**From:** Rich Elliott <elliotttr@kvfr.org>  
**Sent:** Thursday, August 23, 2012 9:40 AM  
**To:** Jeff Watson; Dan Valoff  
**Cc:** Joe Seemiller; John Sinclair  
**Subject:** RE: Notice of Application

Regarding the Webb Conditional Use Permit for operation of a Home Occupation / Party Barn, KVFR has the following input:

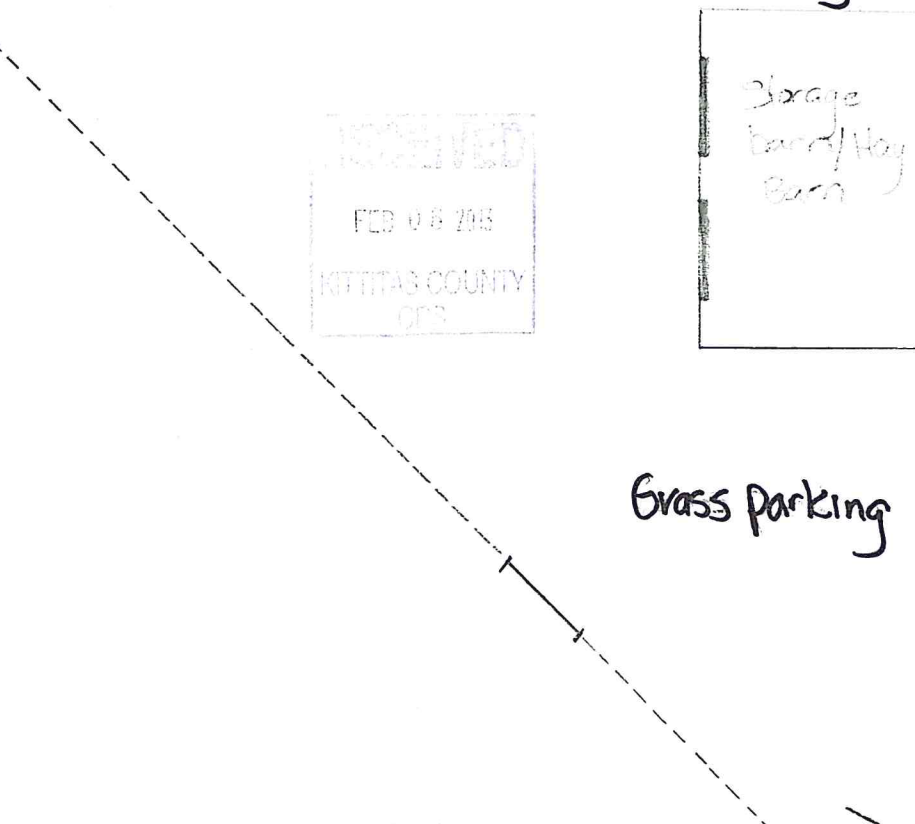
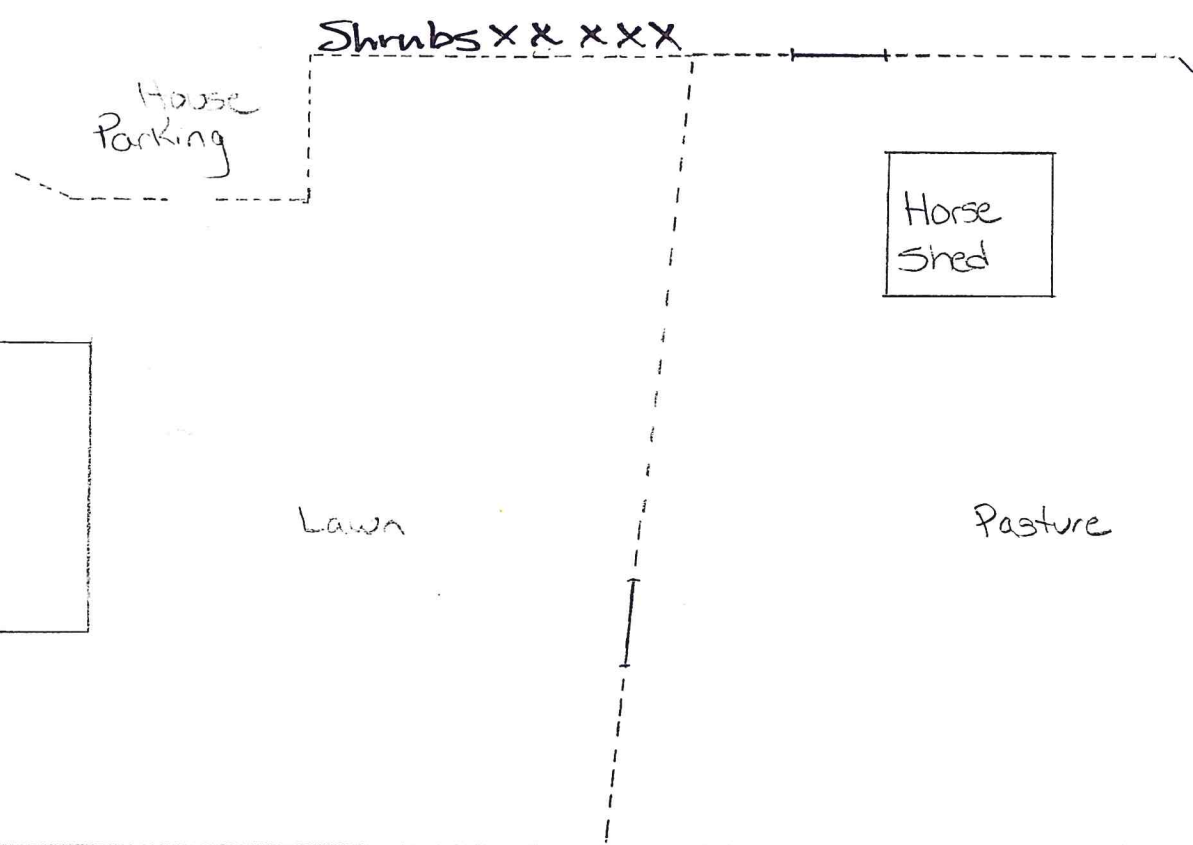
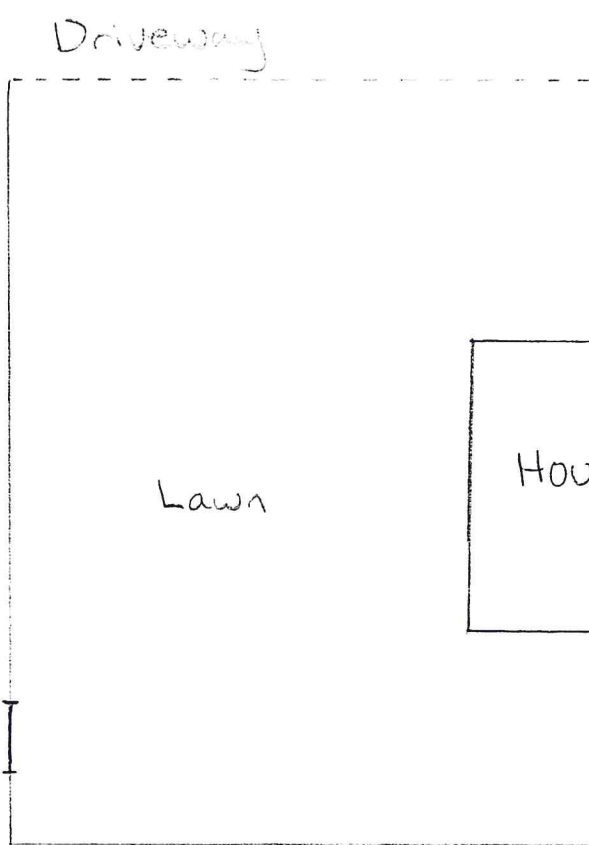
1. I would assume this occupancy would be classified as an assembly occupancy and would therefore likely be required to install and maintain fire detection and suppression systems.
2. Water supply may also need to be addressed.
3. Given the transient nature of these types of occupancy, we would request that the applicant supply a parking and access drive plan that will ensure fire department access during events.
4. General access should comply with Appendix D of the current fire code. Aerial access roads (26') will be required.
5. Addressing will need to be visible from both directions will need to be visible from both directions of travel on Badger Pocket Road.
